**Re: PCD File No. PPR2329  
The Rock Commerce Center, 1st Review  
Response to Comments**

Please accept this letter on behalf of Central Development, LLC, the applicant for The Rock Commerce Center. We received your comment letter dated November 9, 2023, regarding the application and we offer the following responses:

GRADING PLAN

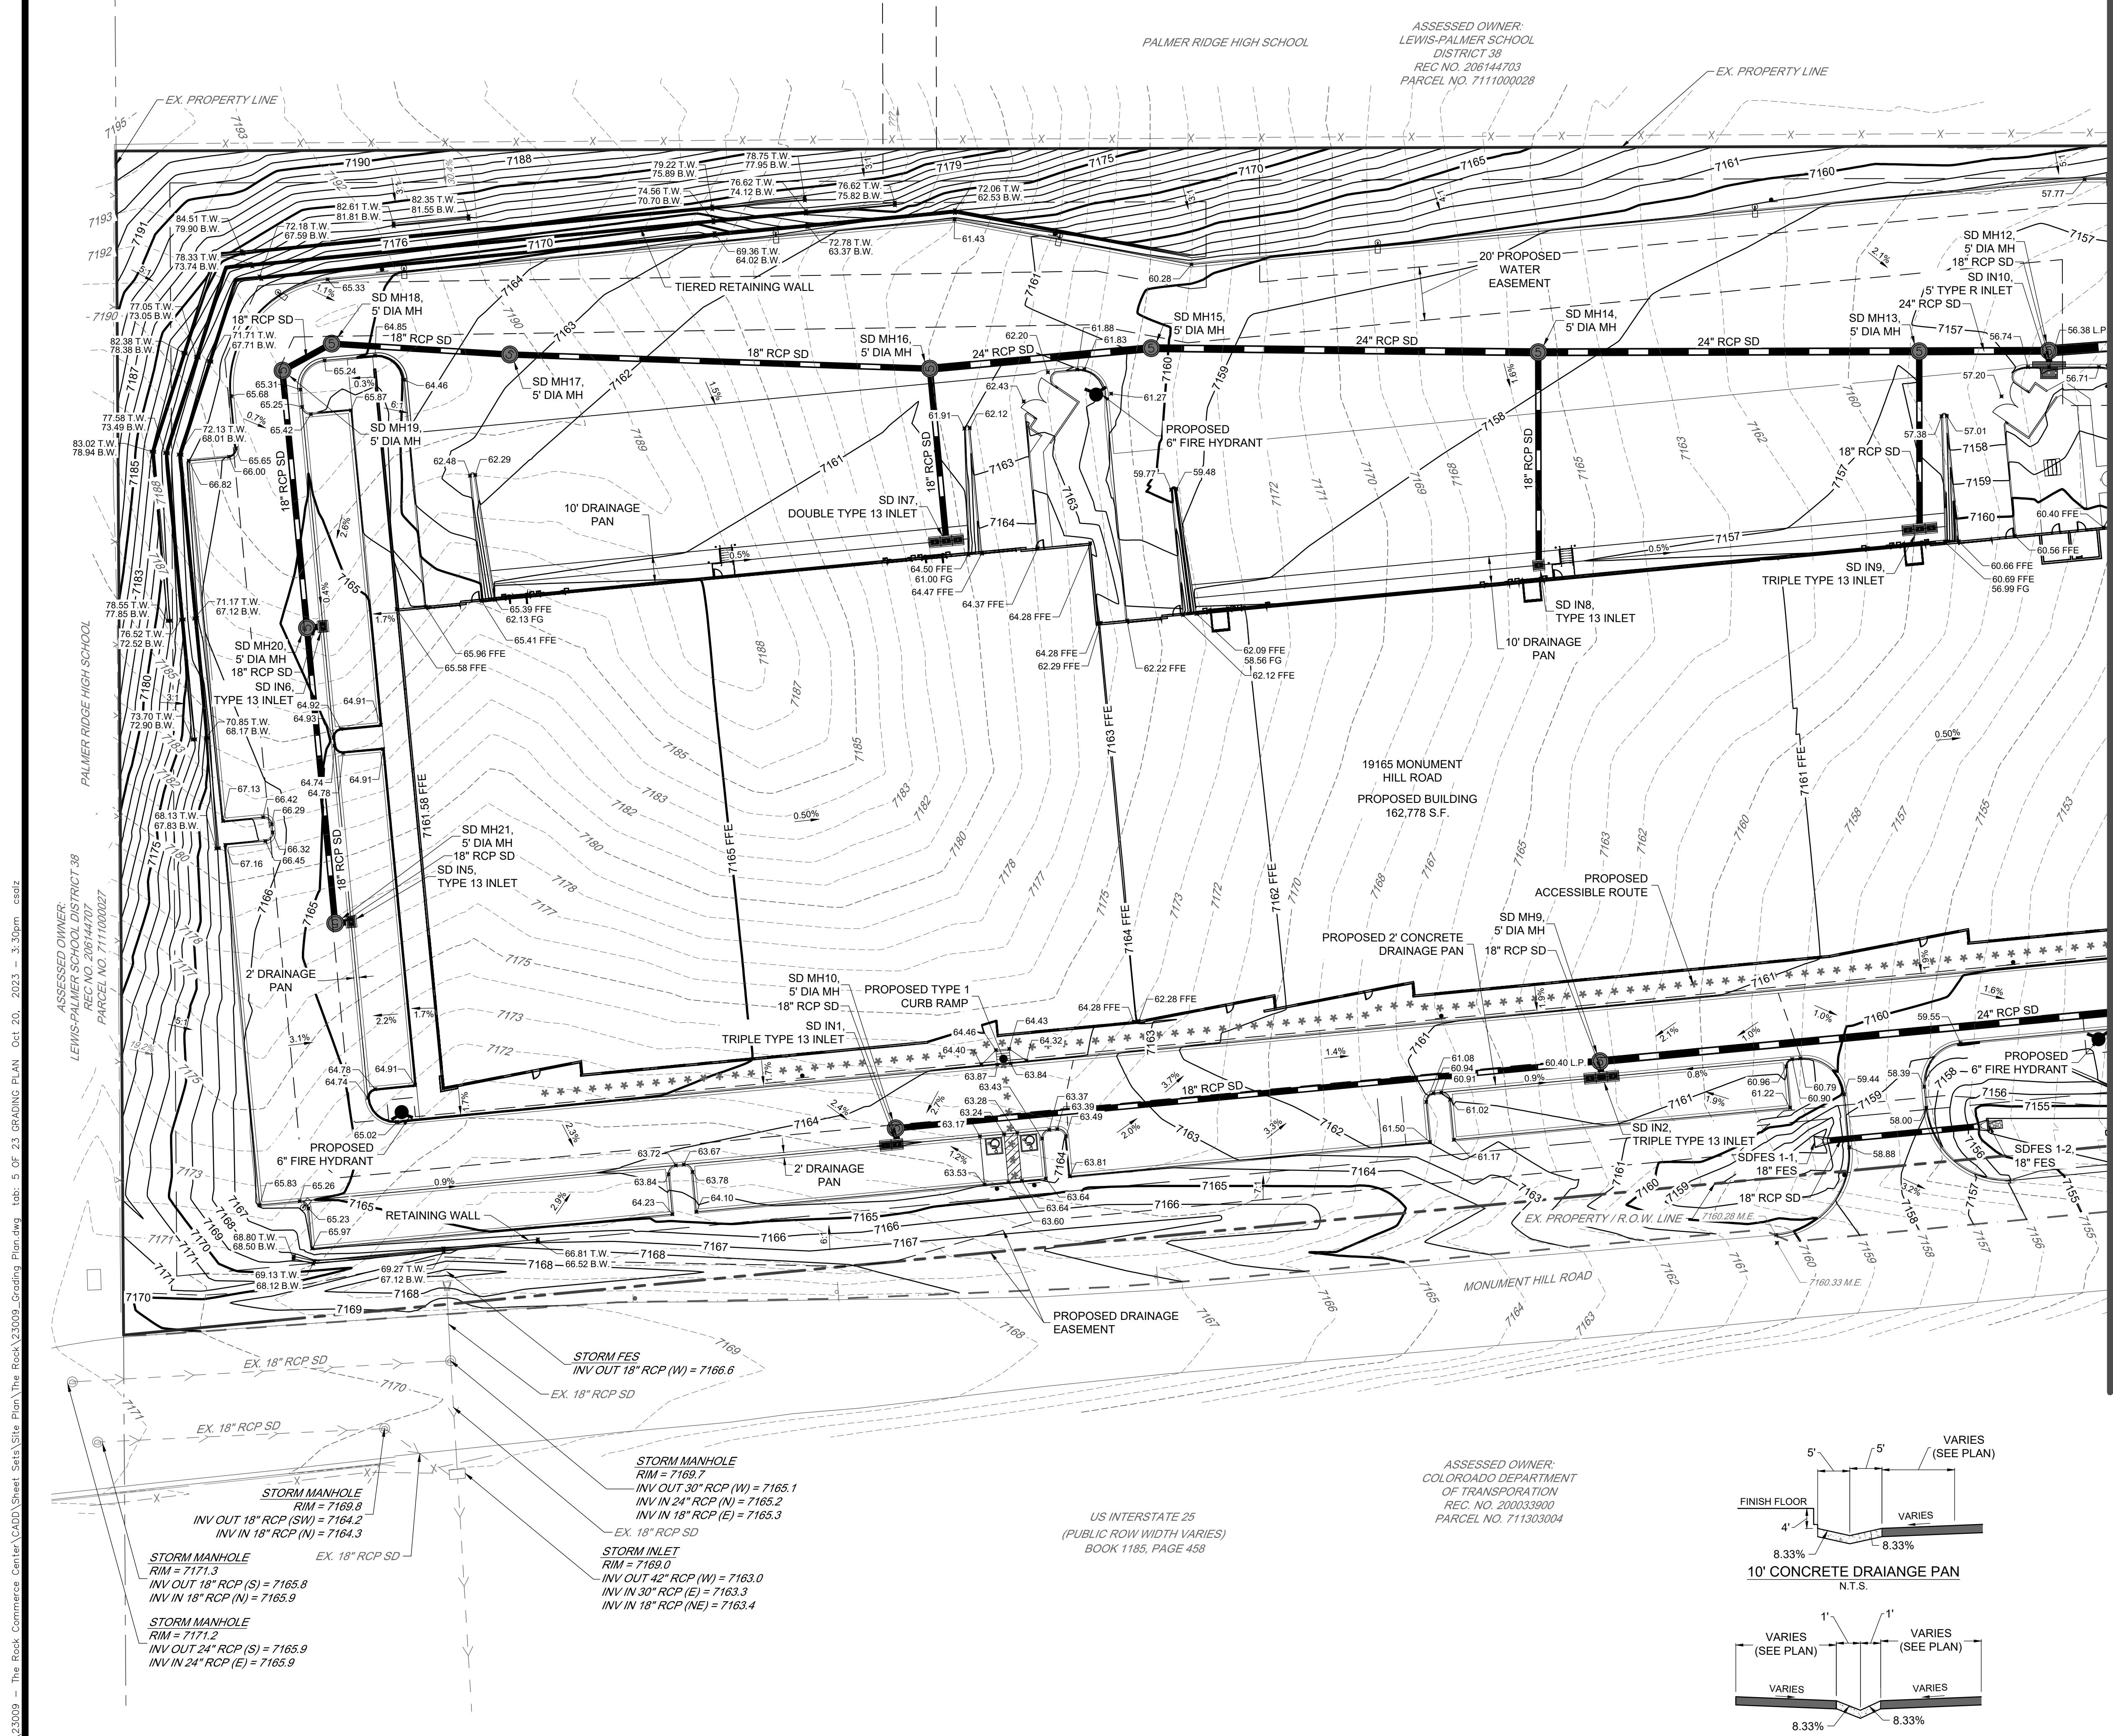
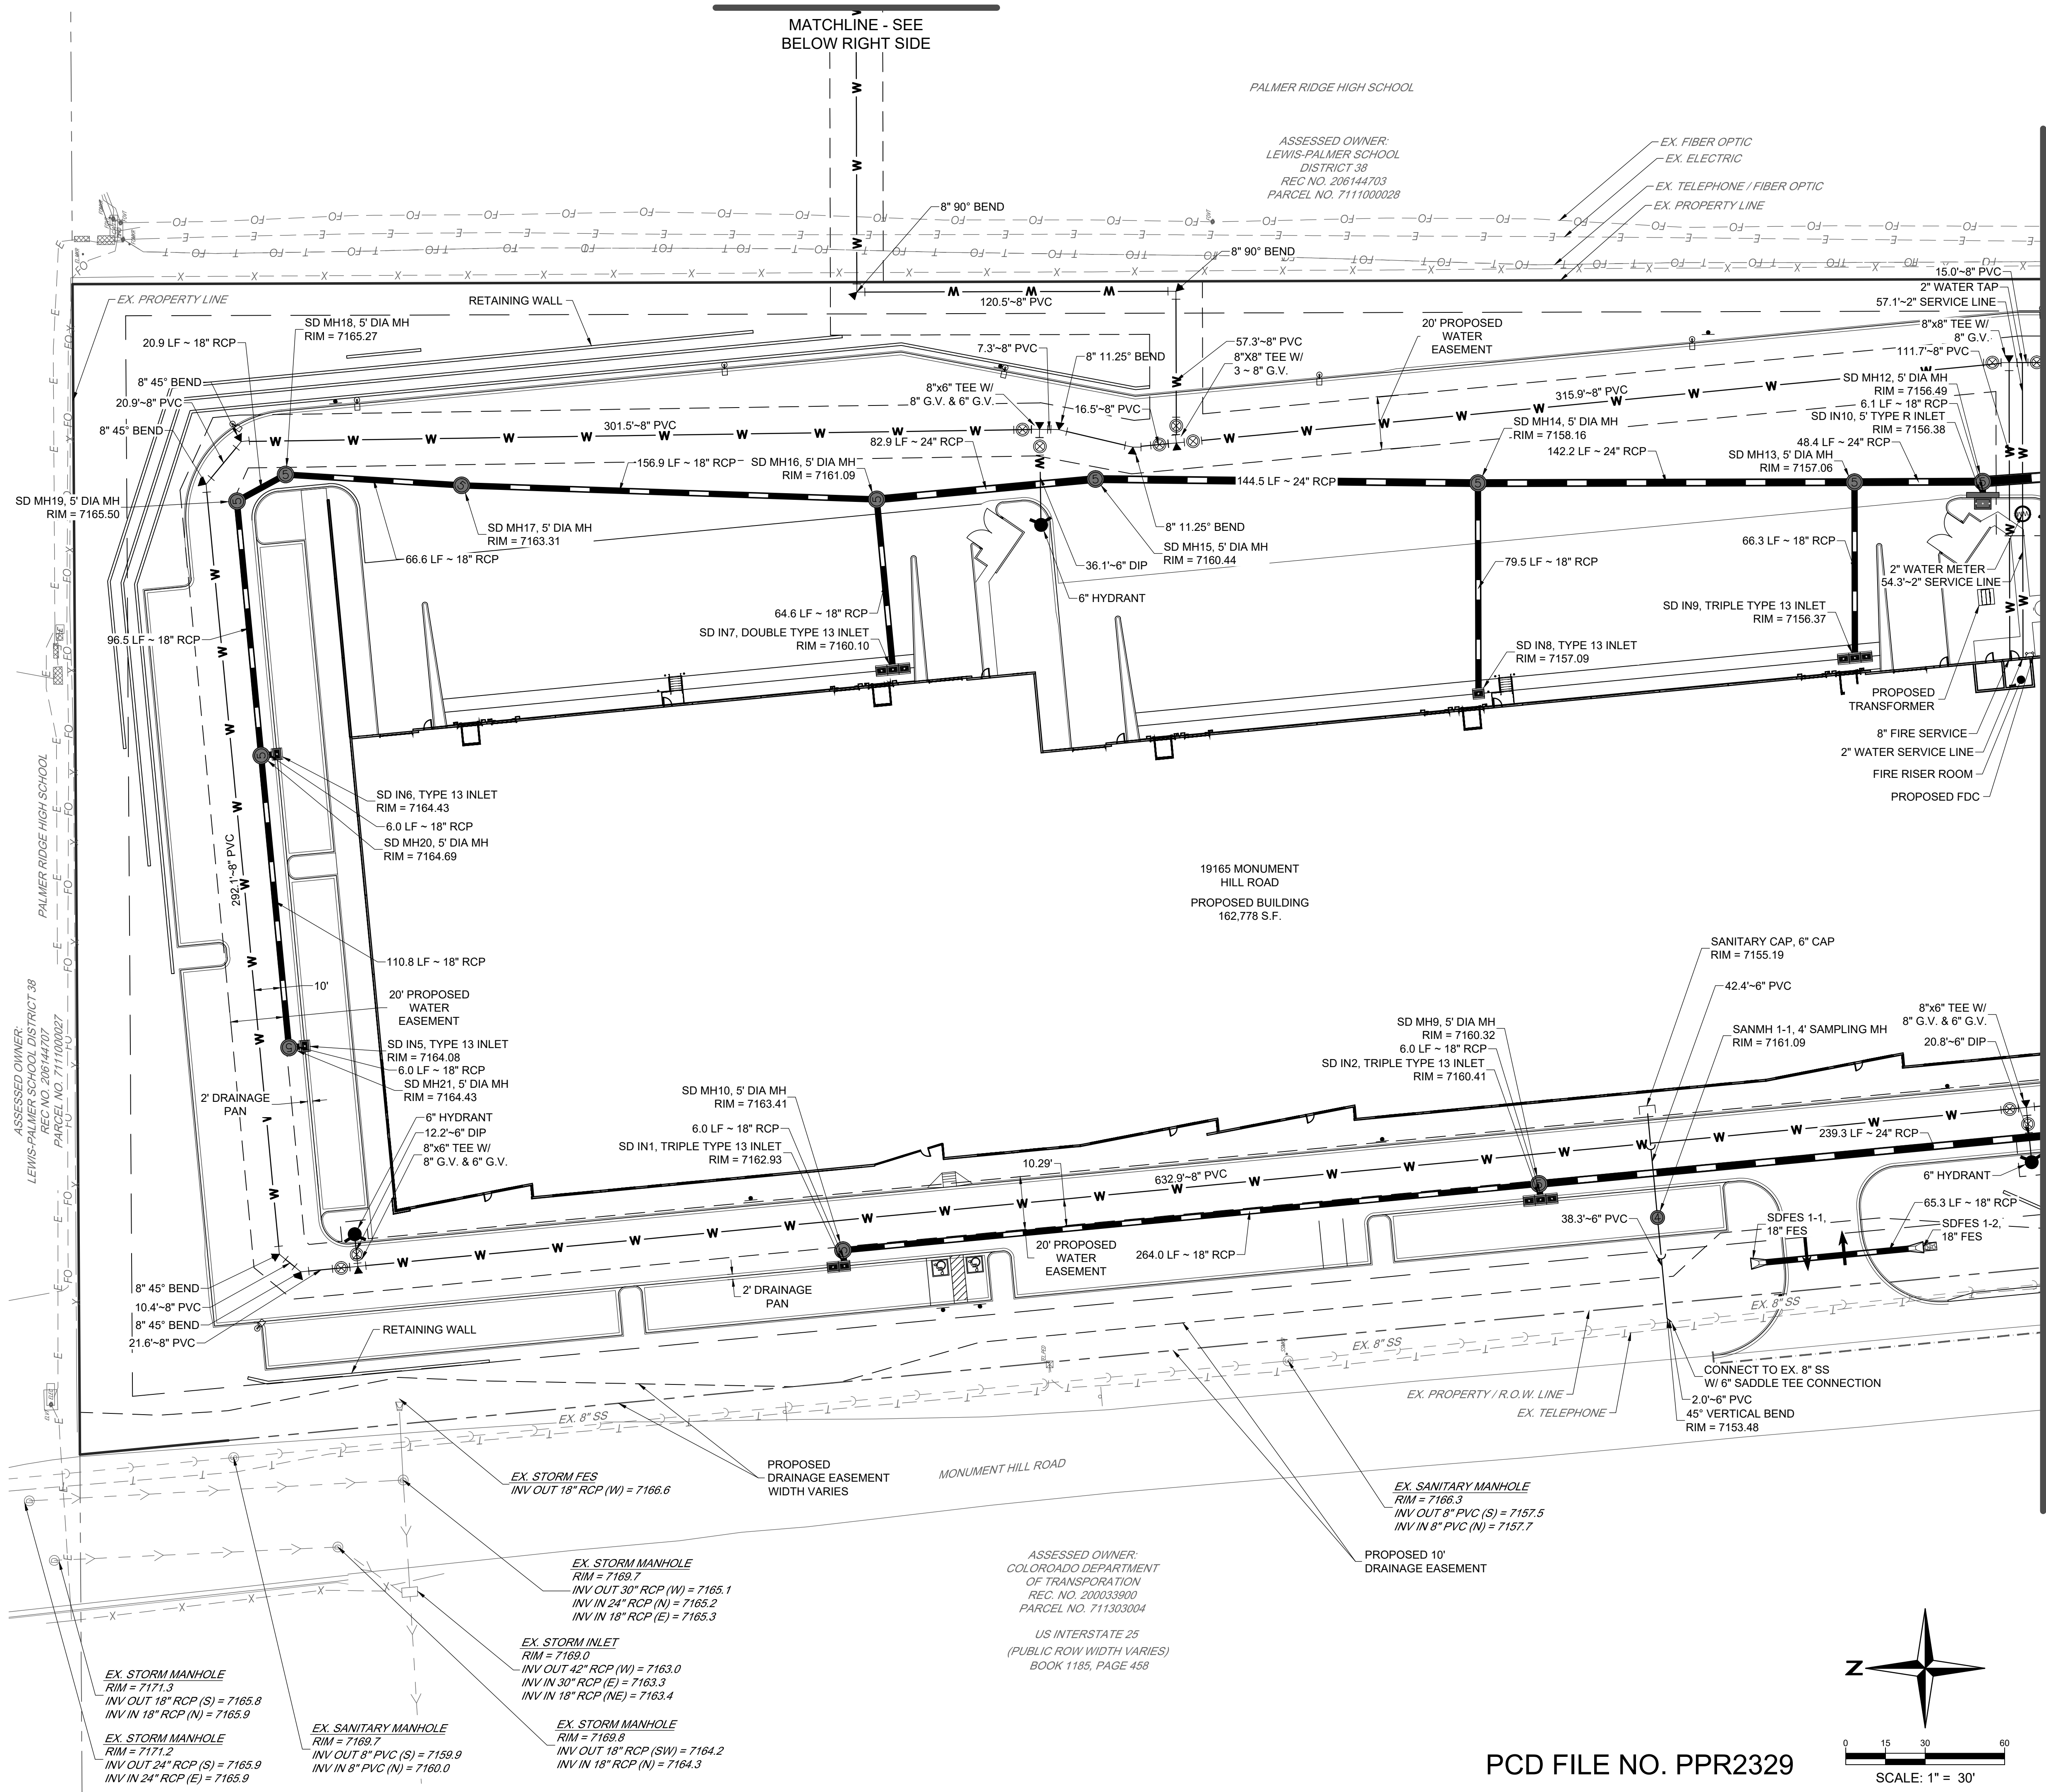
7. Include detail that shows tiered walls, including distance & slope between. Will any walls need a drainage pan to direct flows?

**Response:** The retaining wall detail on this sheet was updated to show the tiered walls including distance and slope between the walls. None of the walls will require a drainage pan. The detail on sheet 6 remains showing a single wall.

SITE DEVELOPMENT PLAN
 THE ROCK COMMERCE CENTER
 LANDSCAPE PLAN 'A'

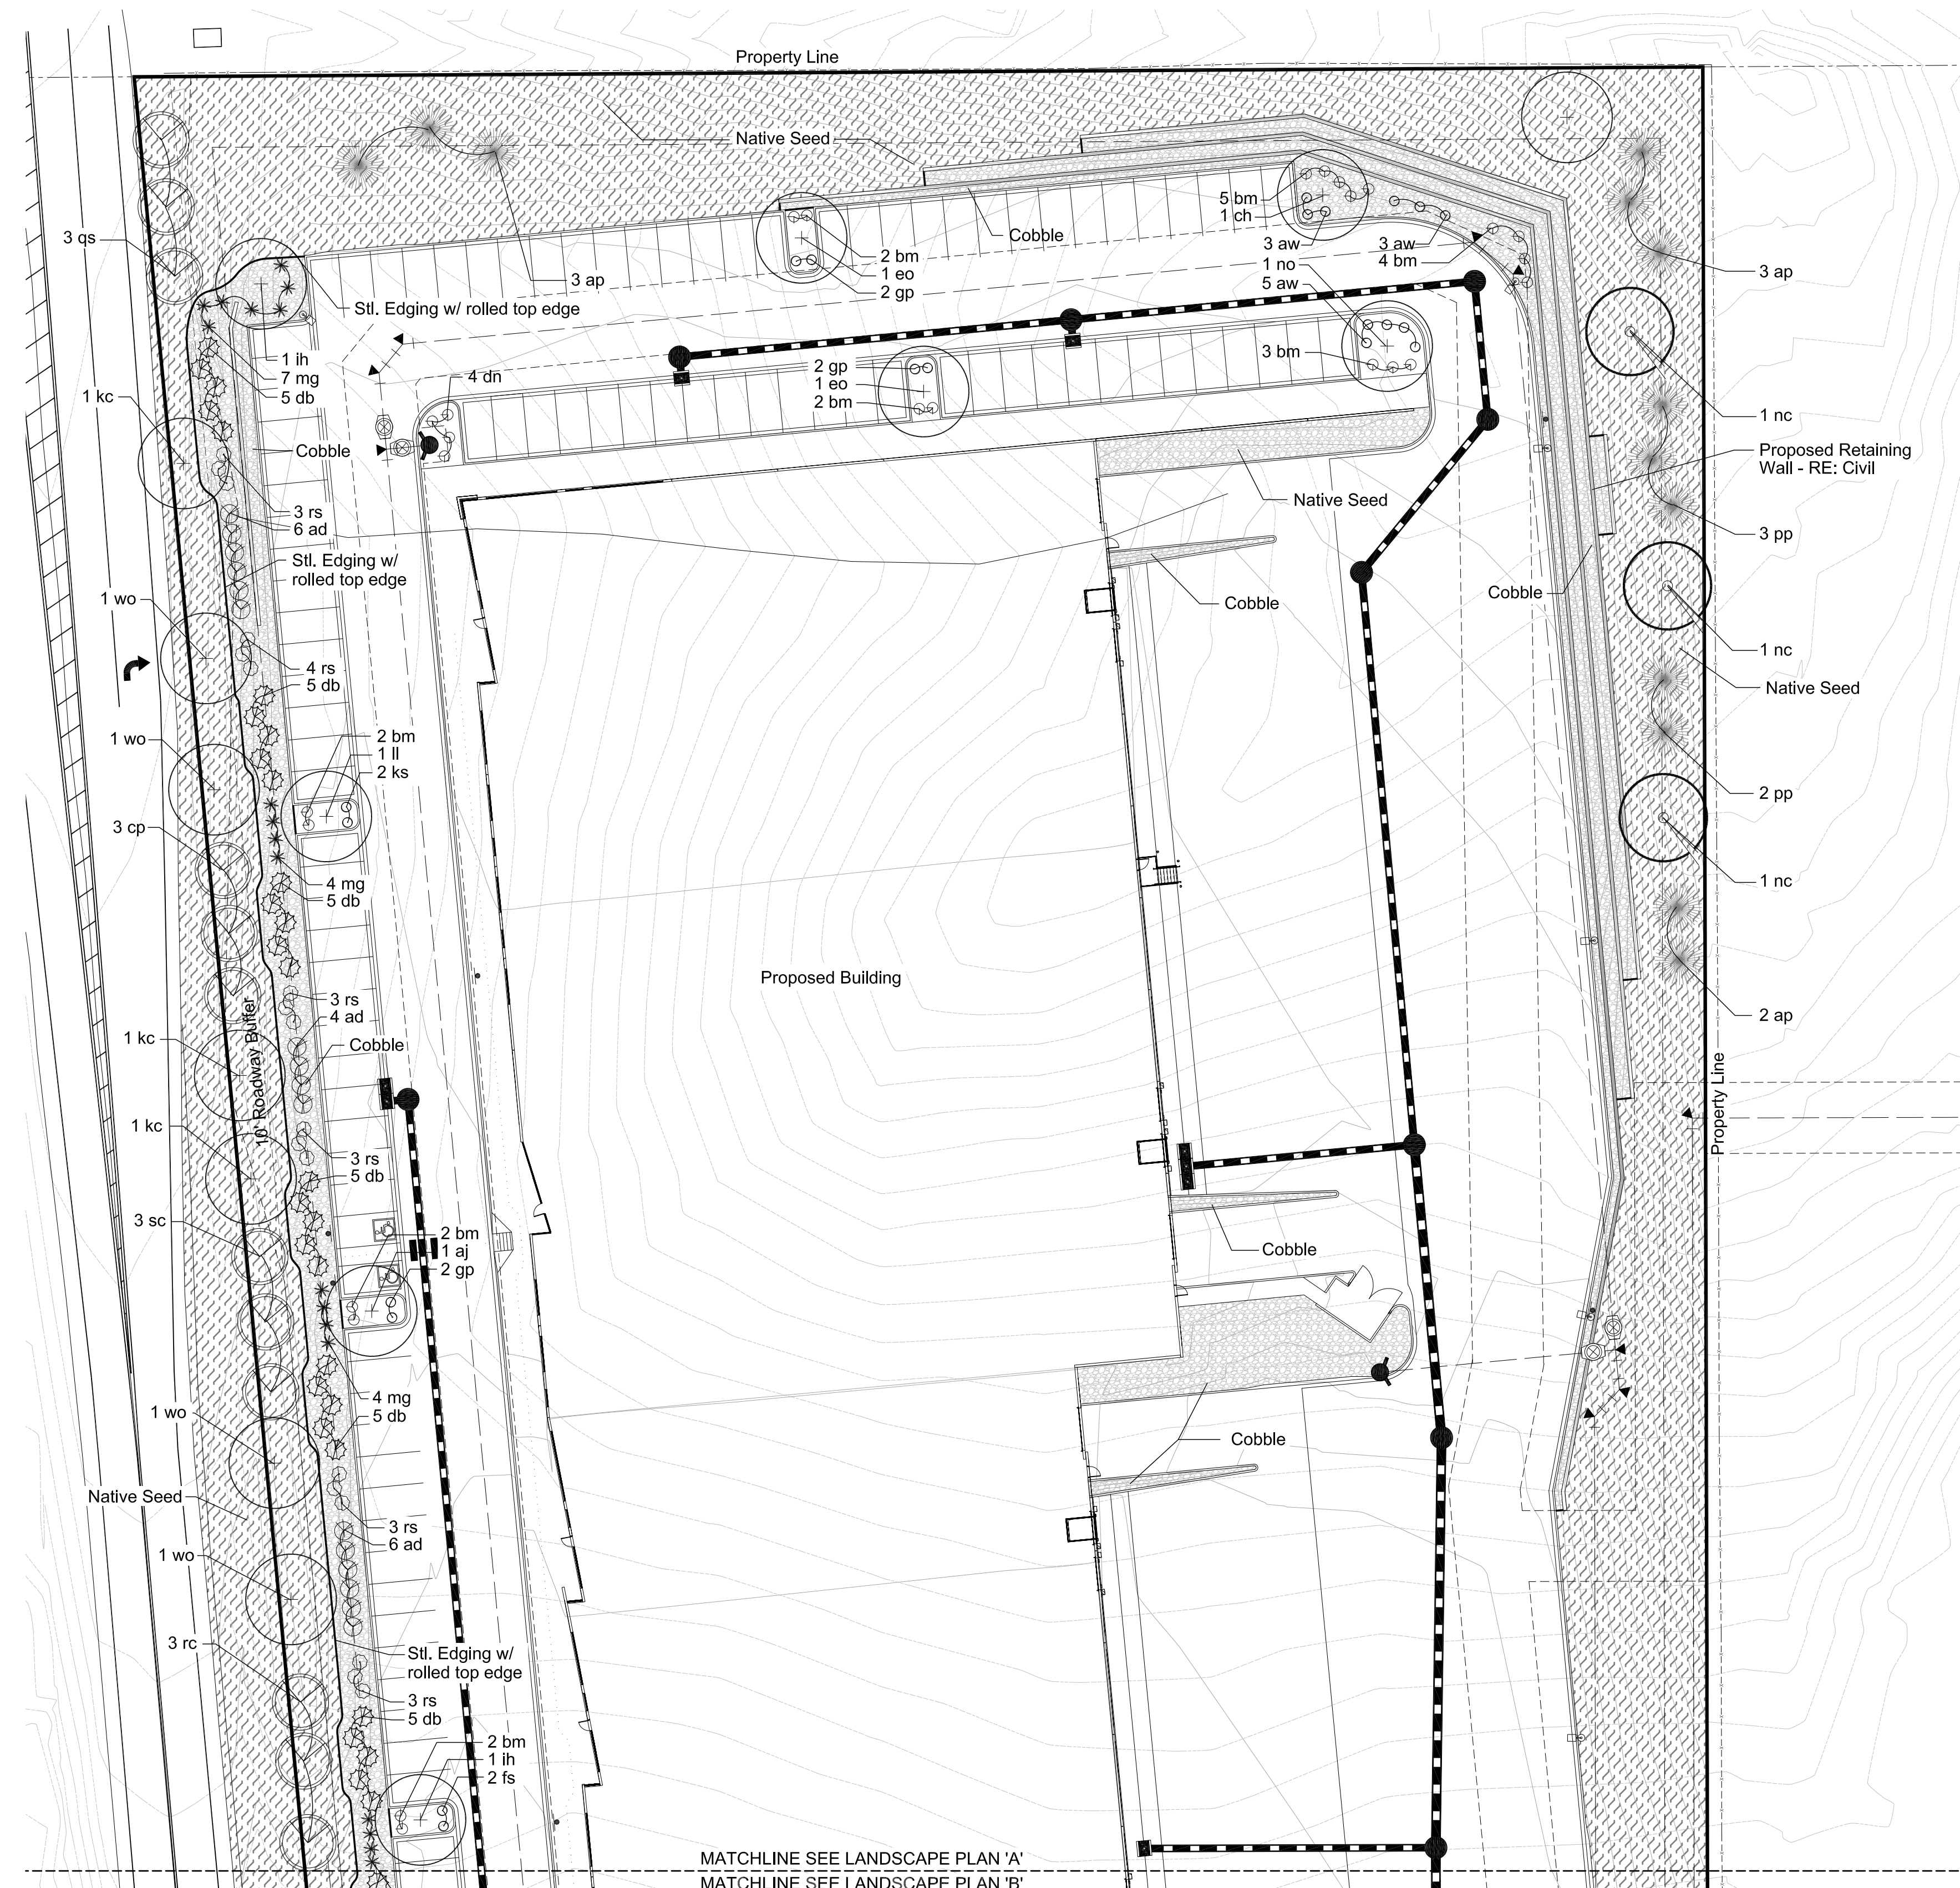
8. Show and label right-of-way.

**Response:** This label was added as requested.
